Lorenzini Waterfront Residence

Mercer Island, WA

CD FRAMING REVISION CALCULATIONS

December 10, 2021

SHEET NO.
S2.2

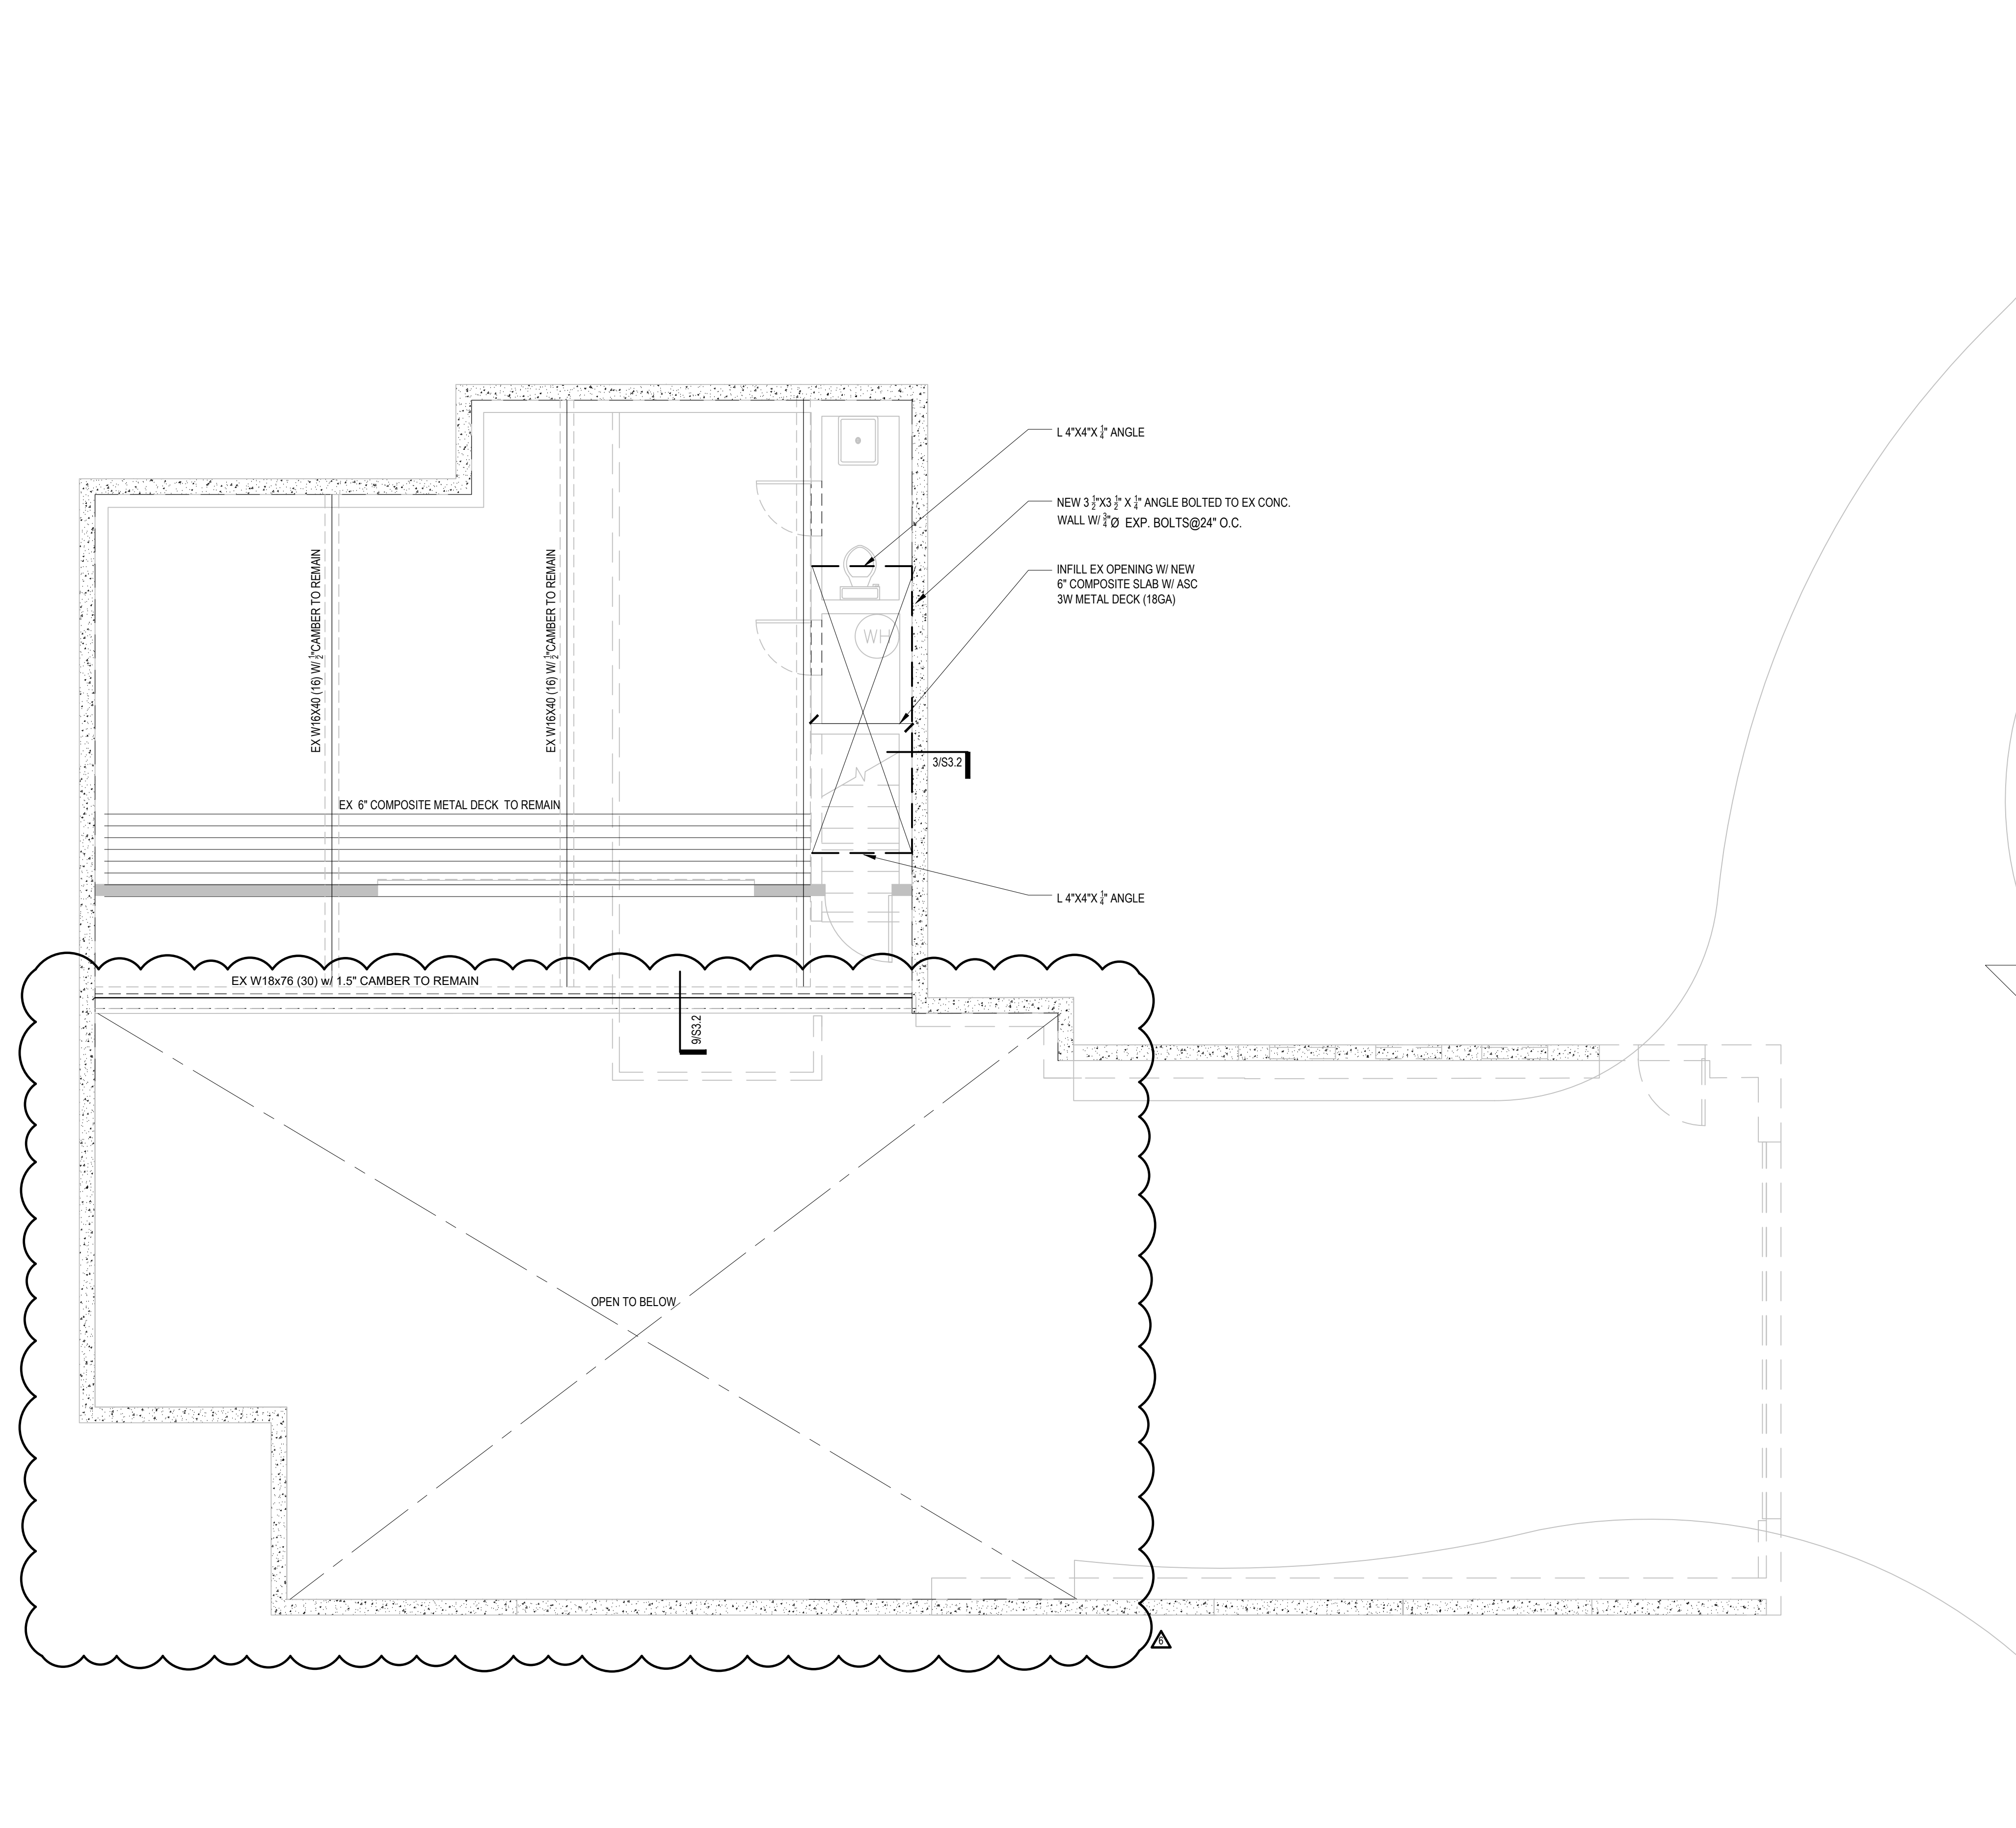
- S2.2 – Framing updated around low roofs at entry and master bathroom.
- S2.3 – Infill framing removed due to reduced footprint of enclosed garage area.

CD Changes to Roof Framing

C New/Revised Entry DL216 SL25

SHEET NO.
S4.2

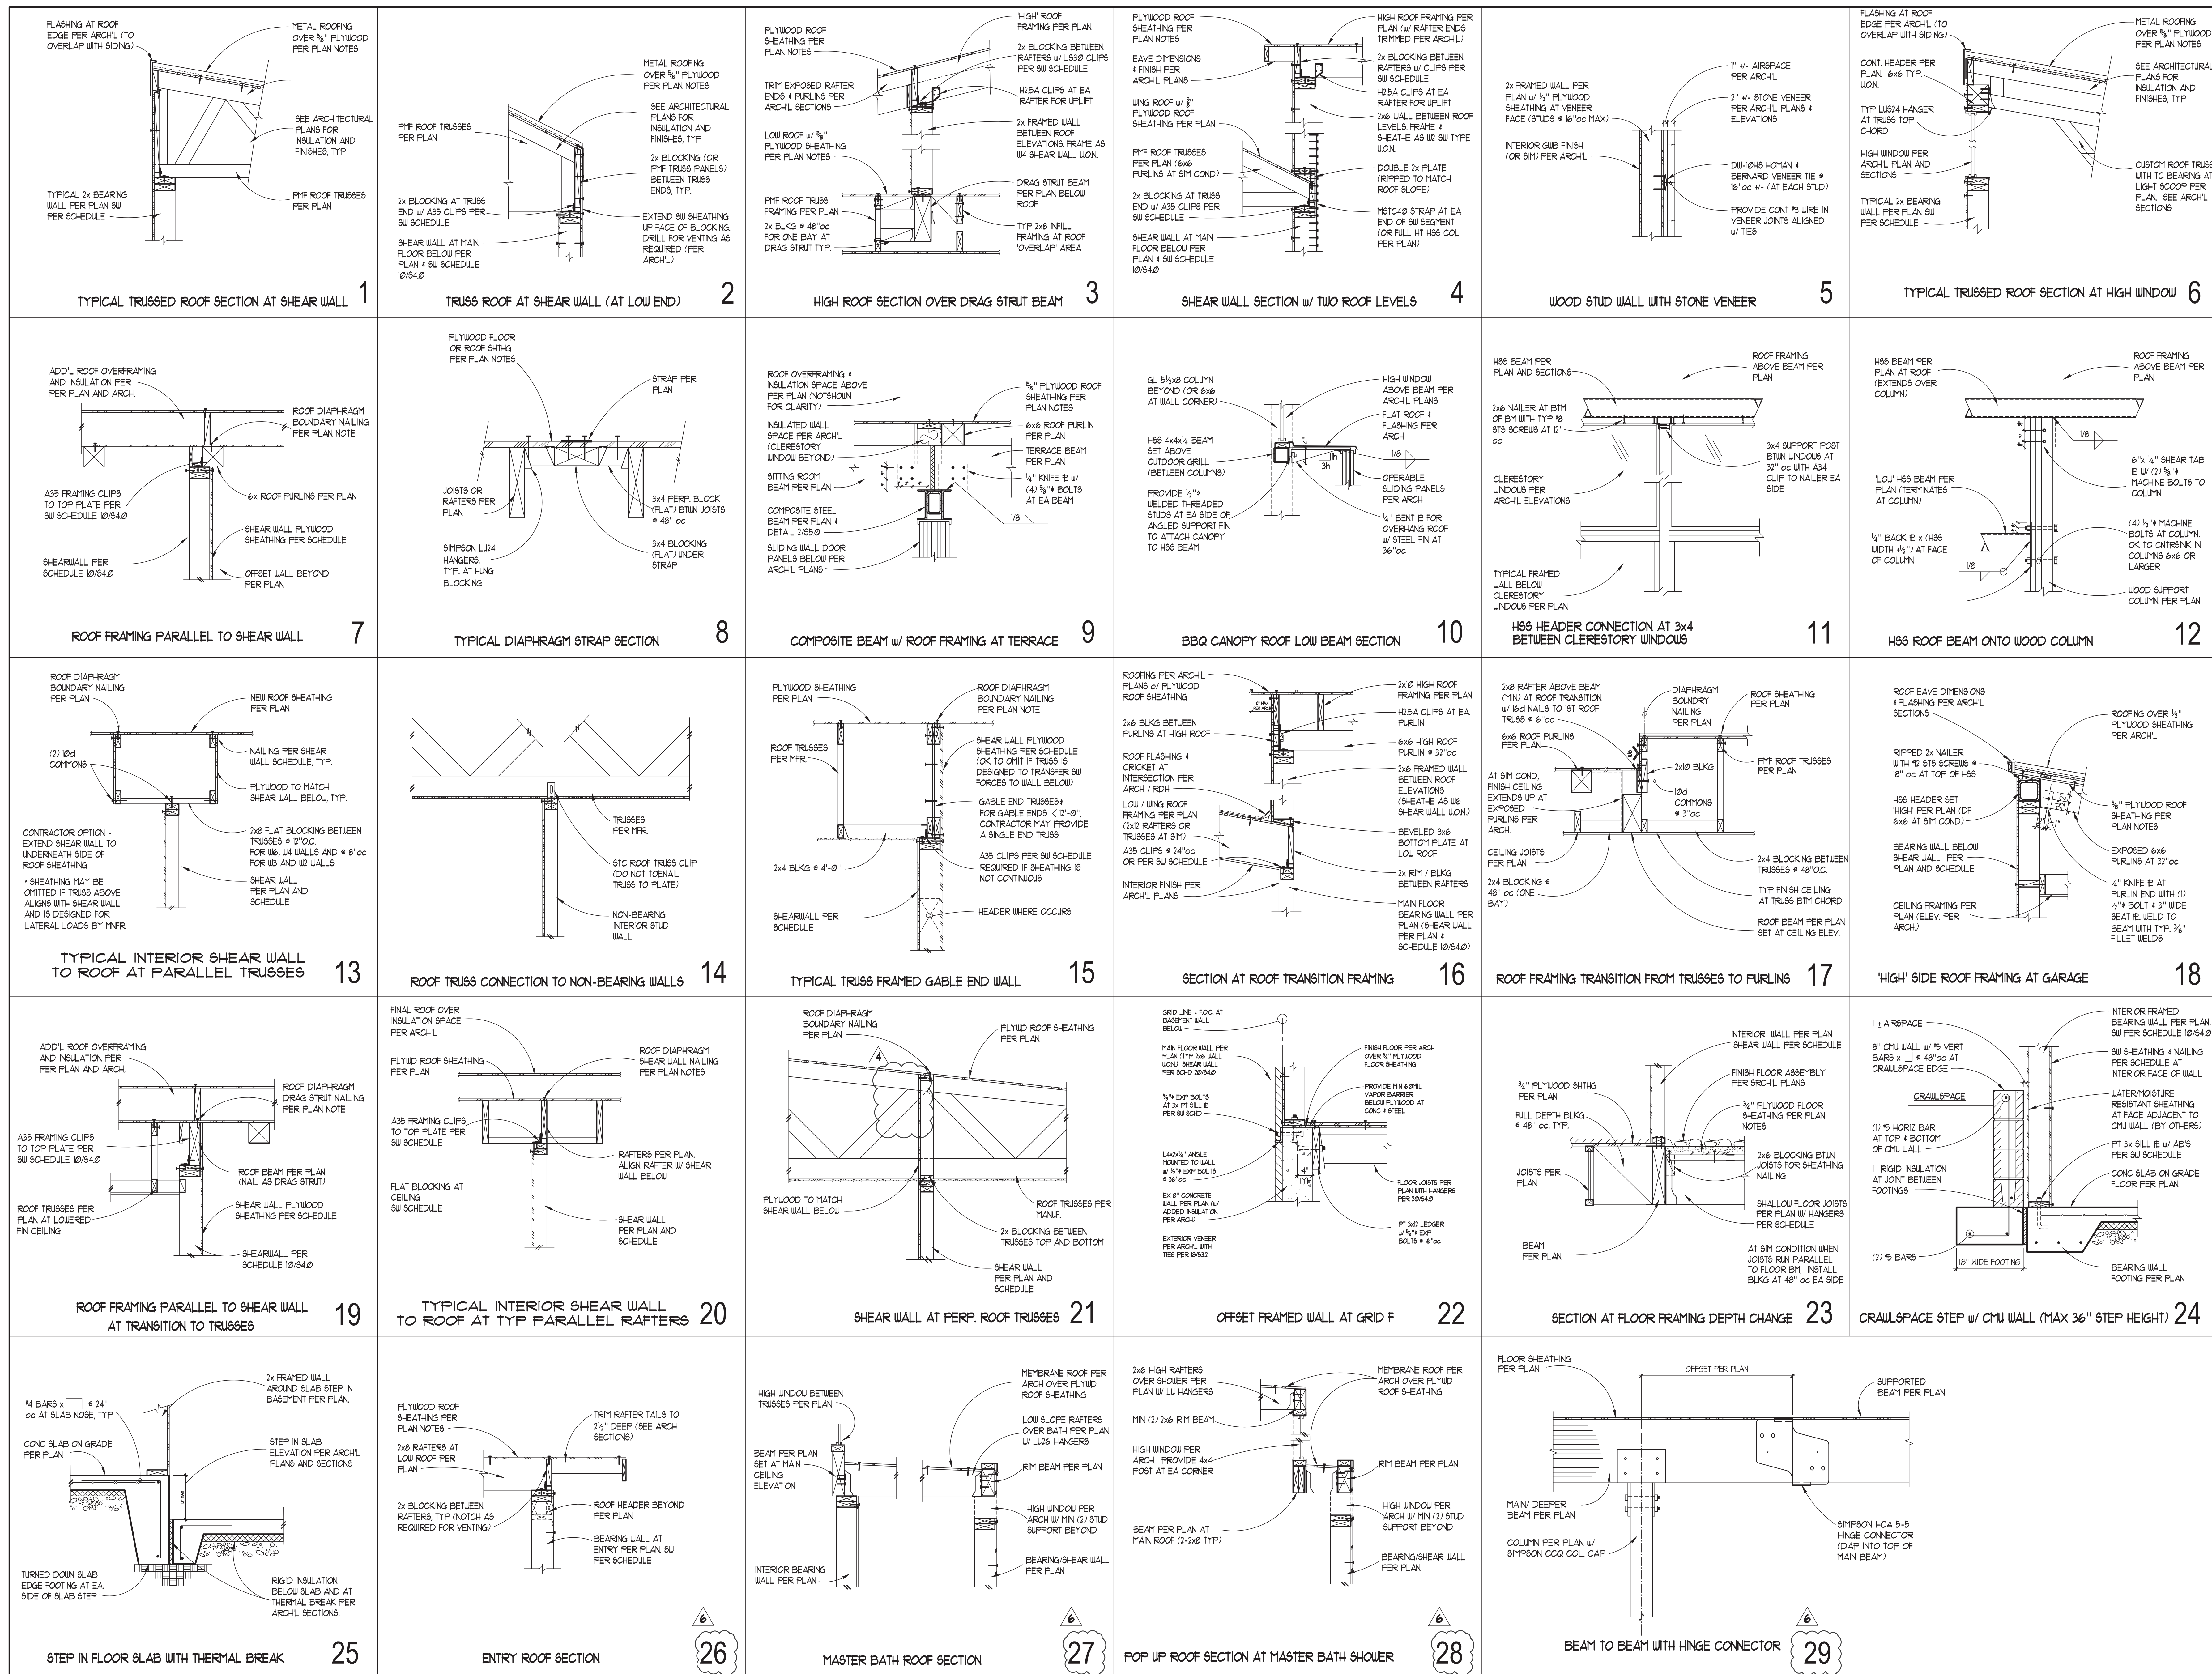
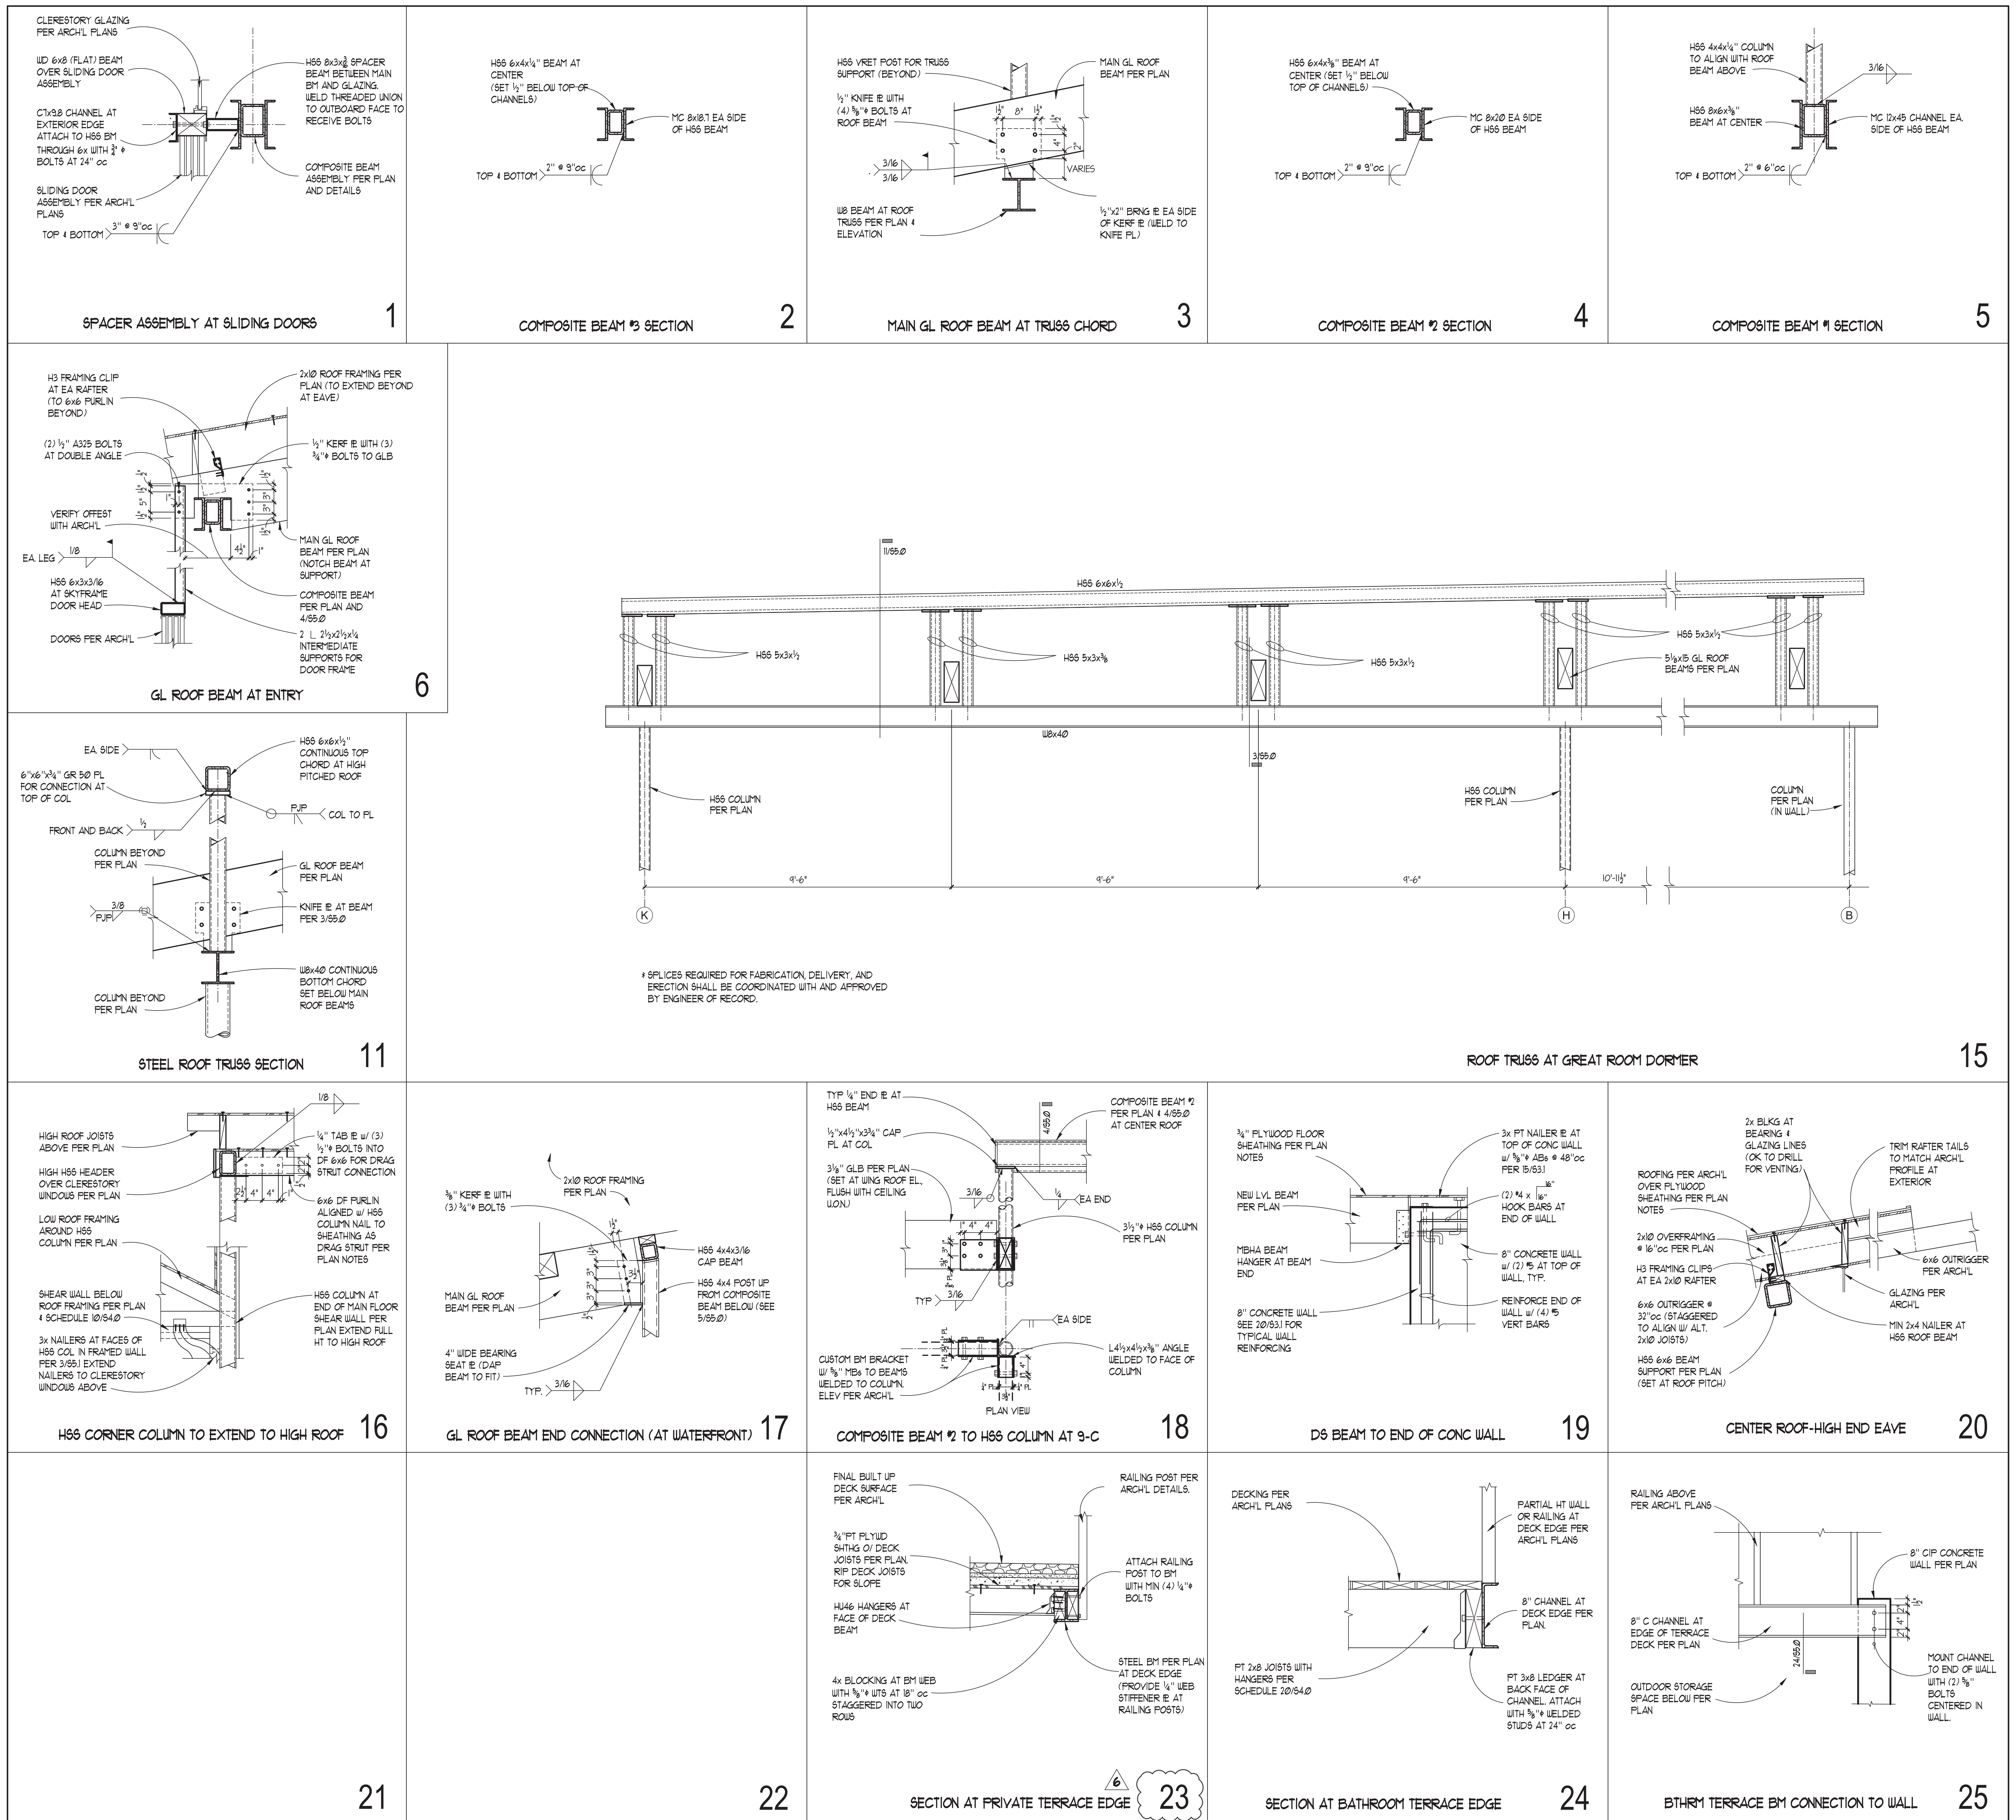
- S4.2 – New details for updated framing at east wing and low roof areas.
- S5.0 – New detail 23 added for steel beam at edge of terrace.
- S5.1 – Details updated for revised floor assembly depths
